**From:** Doris Yau  
**Sent:** Tuesday, 9 November 2021 12:14 PM  
**To:** Rebecka Groth  
**Subject:** RE: Notice of Exhibition – Access Logistics Park (SSD-17647189)

It is noted that the proposal is about subdividing the land into 16 lots and to construct and operate a warehouse in lot 2. A SEPP 33 assessment is also included as part of the EIS and verifying the warehouses in Lot 2 would store, handle and transport dangerous goods below SEPP 33 triggers. The same document also indicated that the intent of the individual warehouses in the remaining lots would not handle dangerous goods exceeding SEPP 33 thresholds. Although non-SEPP 33 triggered development generally imply the risk of a facility and its extent of consequence would remain onsite for a typical industrial lot area, some of the industrial lots in the proposed subdivision plan are relative small, additional mitigation may be required to ensure the industrial warehouses would not generate cumulative risk. As such, it is requested the applicant to respond the following question:

Figure 24: 884-928 Mamre Road - Masterplan (Source: Nettletontribe)

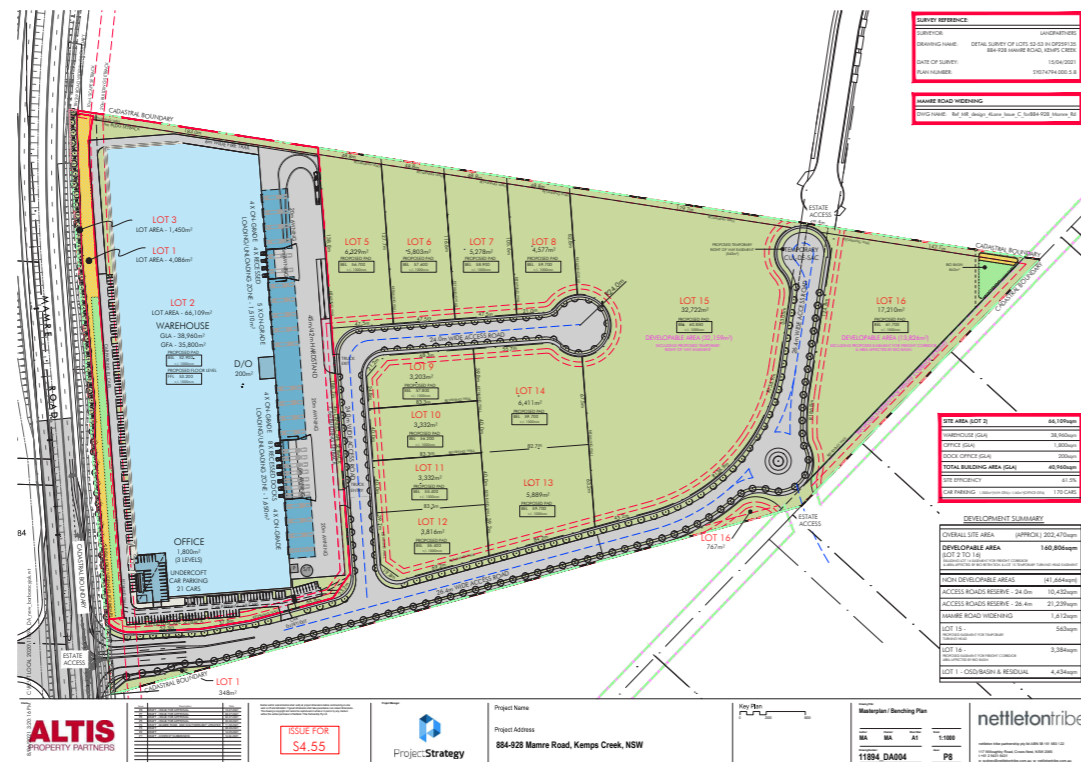
Given Lot 5 to 8 are relatively smaller lots of 50m width and Lot 9 to 12 of approx. 40m, the individual warehouse which may store dangerous goods below SEPP 33 trigger may still impose fire or toxic impacts to the adjoining lots and subsequently requiring cumulative risk consideration, for example when LPG bullet located too close to the lot boundary or toxic gas releases from ammonia refrigeration system. Please clarify what are the mitigation to ensure the future individual Non-SEPP 33 triggered warehouses at these smaller lots would not generate consequence beyond the site boundary.
